PROPOSED IMMINGHAM EASTERN RO-RO TERMINAL

PINS REFERENCE TR030007

RESPONSE TO PROPOSED CHANGES CONSULTATION FROM DFDS SEAWAYS UK PLC

Figure 1-1. Vessel Impact Protection Structures

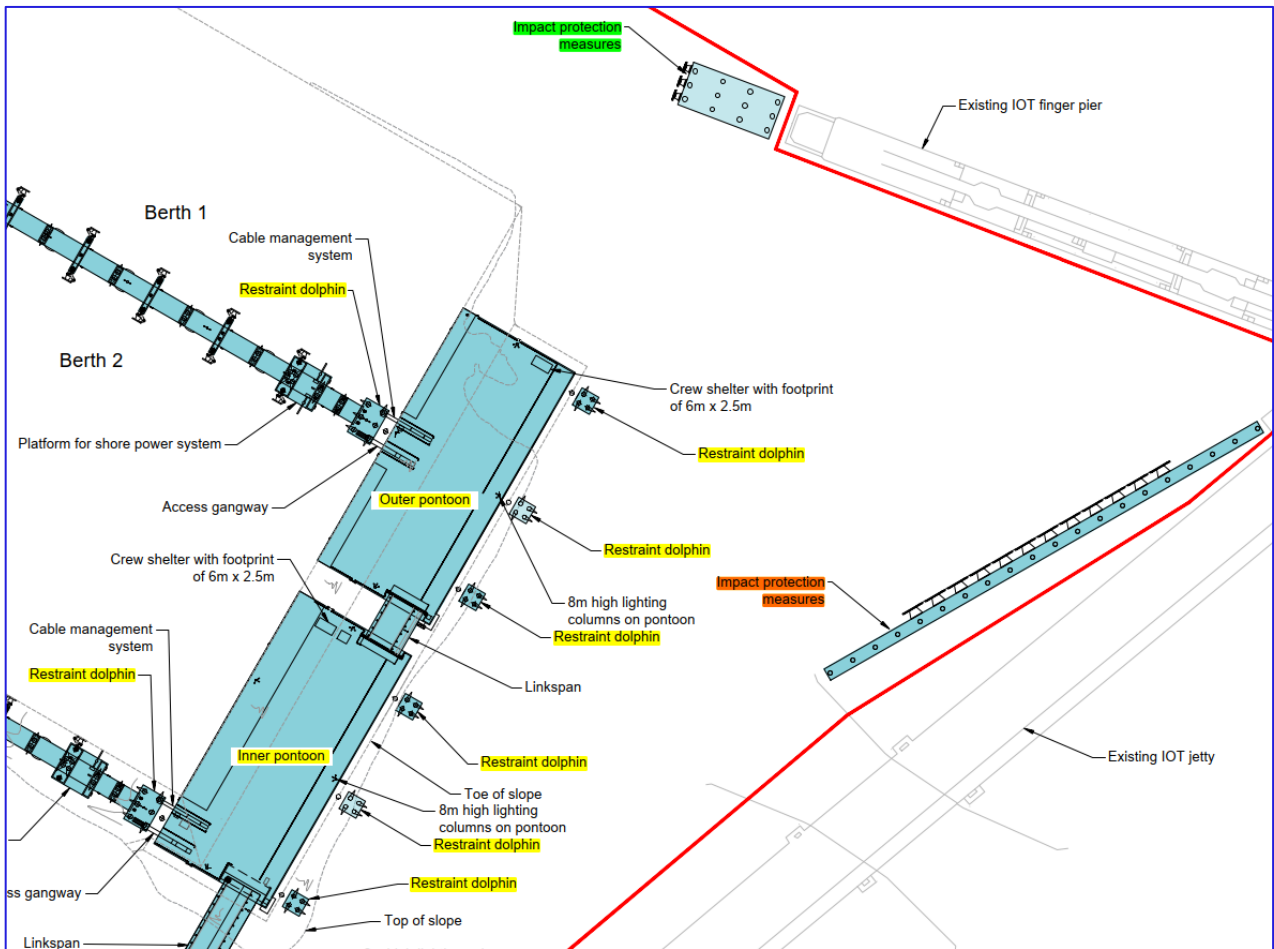
3.2 The letter states that there are no new impact pathways or unique risks in relation to commercial and recreational navigation, however the impact protection added to the end of the IOT Finger

Pier may itself have an impact on navigation as it effectively makes the pier longer, not only on vessels using the IERRT but also the south side of the finger pier, and further navigational simulations of such movements should be carried out with the proposed impact protection in place.

- 7.2.4 The design of Impact Protection Measures 'is still being finalised' (2.5.3 of the ES Addendum) so this consultation is premature. Should the designs change either through further development by the Applicant or following agreement with the IOT Operators, another opportunity should be given for stakeholders to comment on any differing proposal.

- 7.2.5 It is also not clear if the measures are 'sacrificial', i.e., they would only survive one collision and would have to be replaced. If that is the case, the Applicant should indicate whether and in what circumstances they would be replaced and what is intended for IERRT operations whilst waiting for replacement; DFDS would wish them to be replaced immediately and to restrict IERRT vessel movements until replaced.

7.3.4 whether they would be able to withstand a vessel the size of the design vessel,
